PLANNING CONSULTATION RESPONSE

Application No	2026/0548
Proposal	Renovation of existing sports pavilion, including the demolition of existing sports hall and erection of new single storey activity hall, new external terrace and steps.
Address	Carlton Park, Church Street, Carlton, Barnsley, S71 3HG
Date of Consultation Reply	17/08/2026
Consultee	Katie Lawrence, Planning Ecologist

client	BWB Consulting Ltd	created	29jun26
project	Carlton Pavilion	job N°	250704
title	Landscaping Layout : Proposed	scale	1:100 @ A2

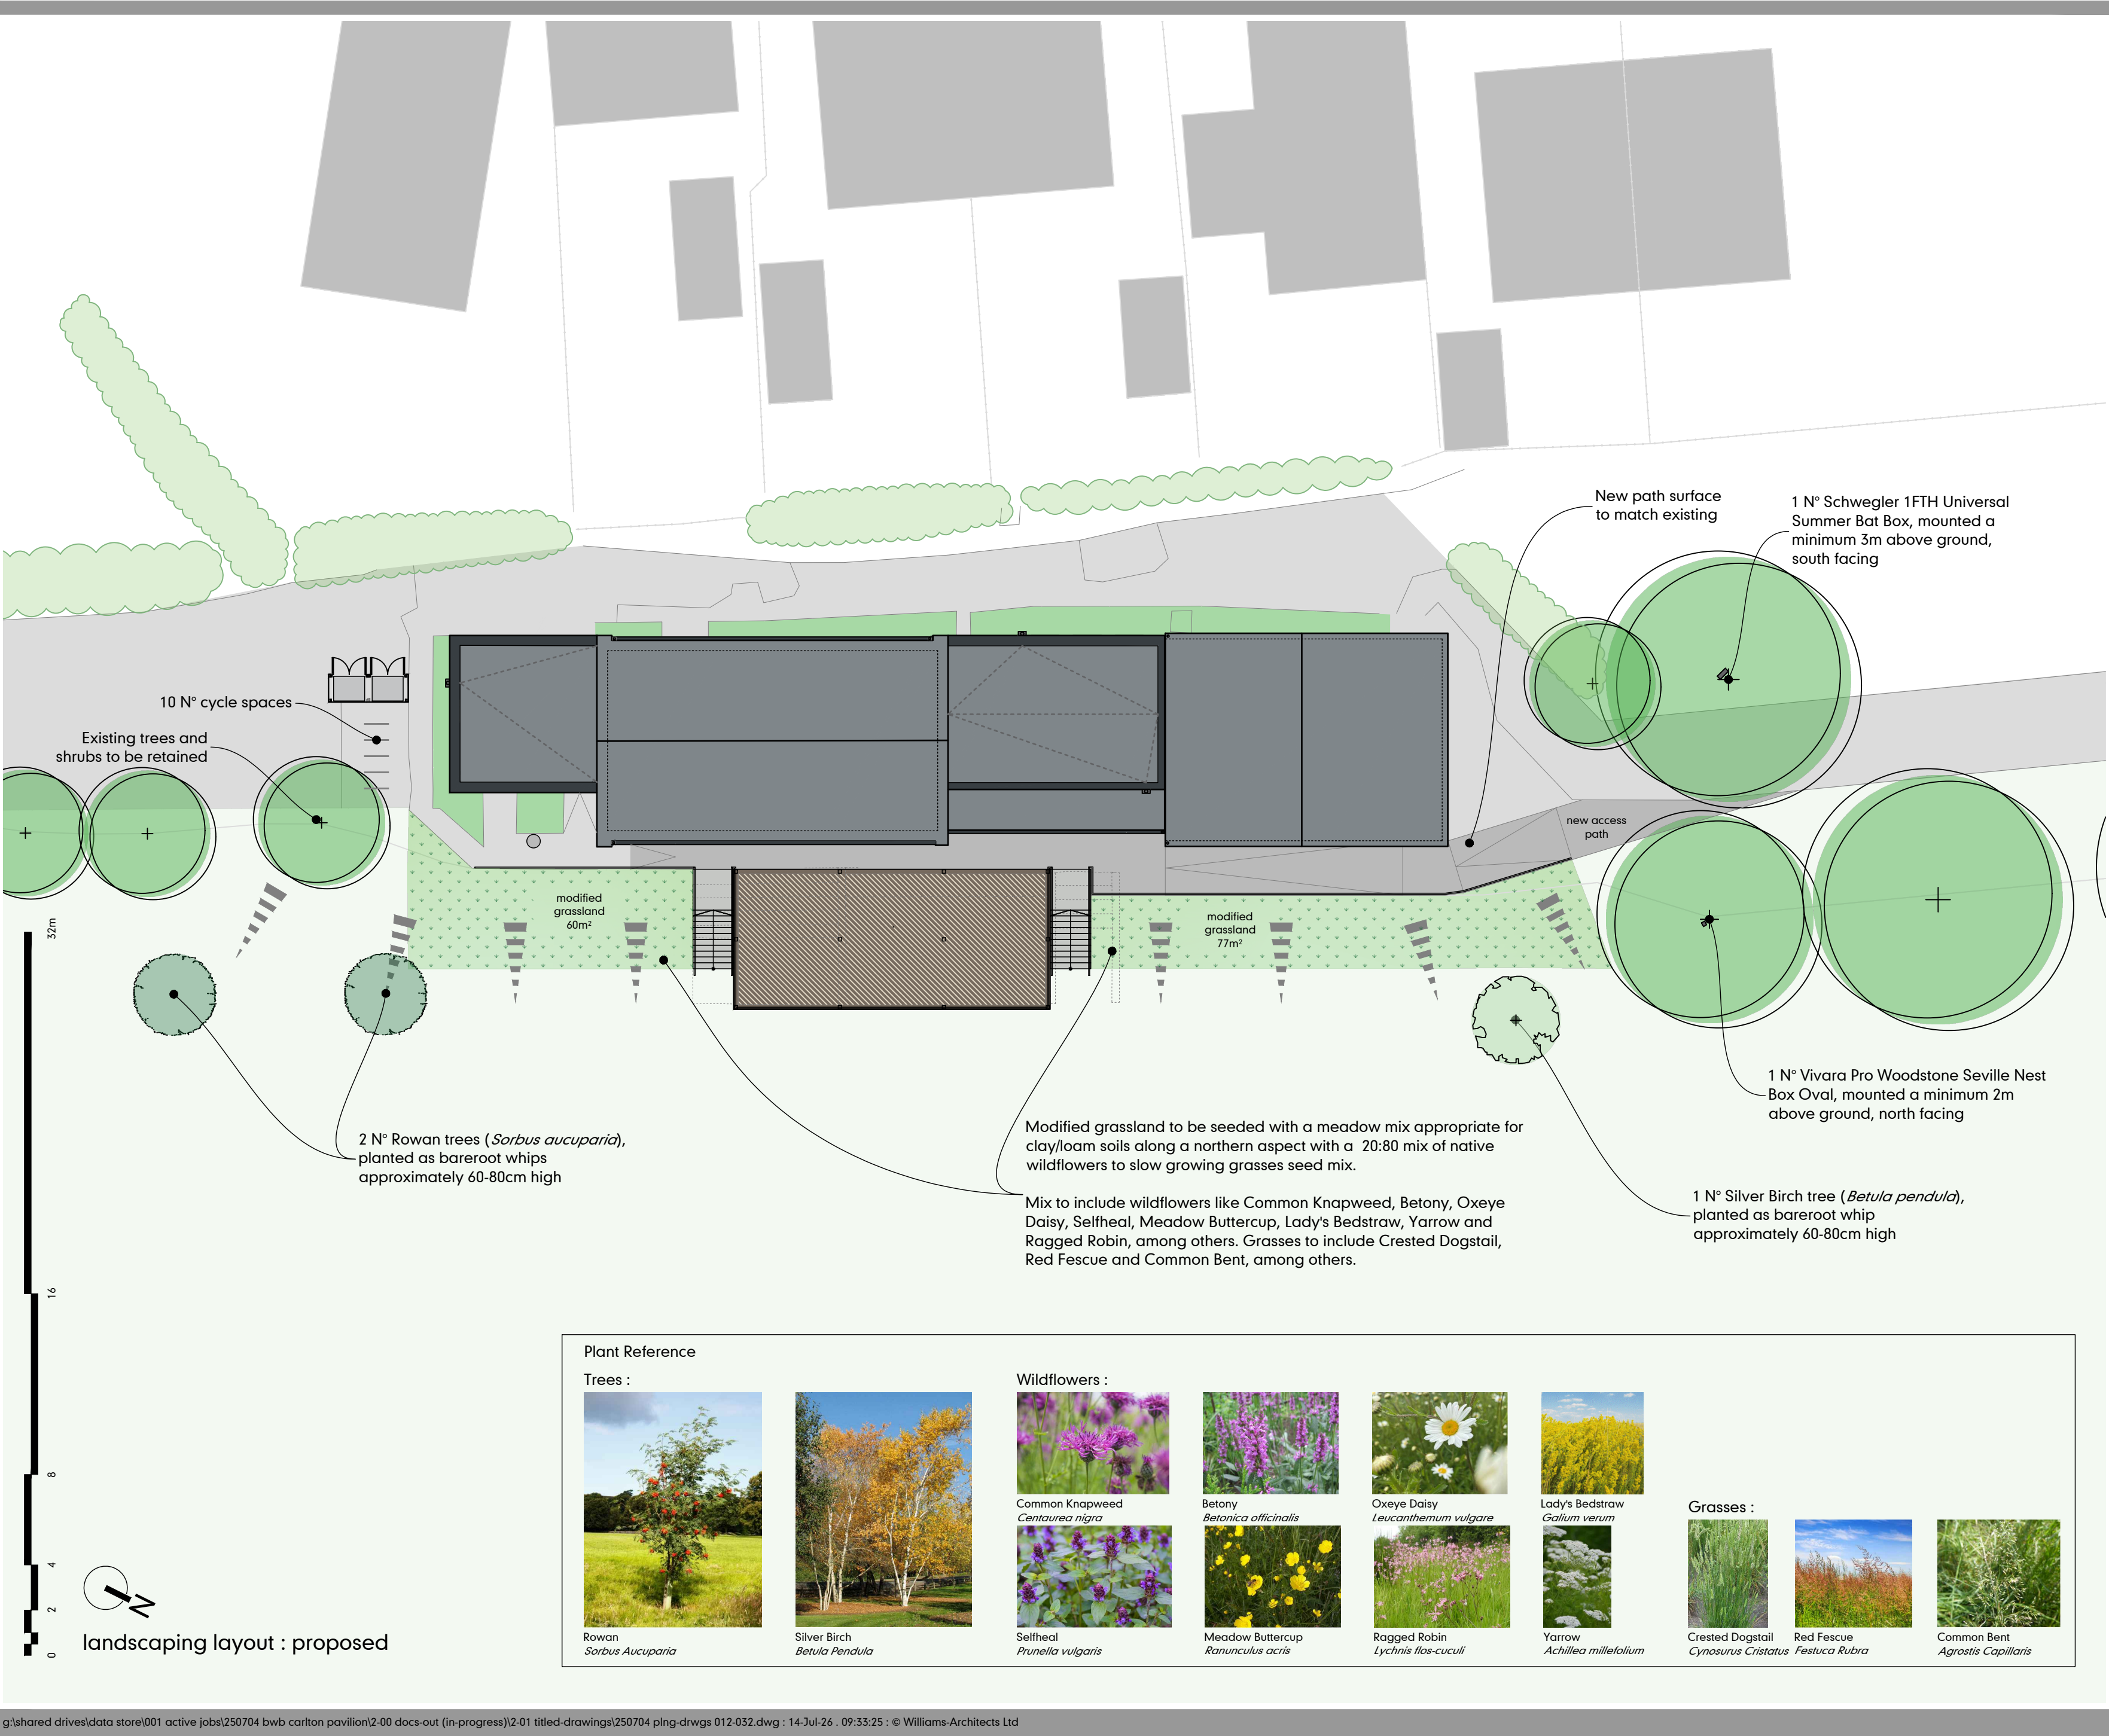
Thank you for providing an updated proposed landscaping layout in support of the above application. This now shows four new individual trees to be planted which will allow for Biodiversity Net Gain (BNG) requirements of the development to be met. As set out in my previous response with this proposed planting a gain of 0.036 habitat units (14.78%) can be achieved.
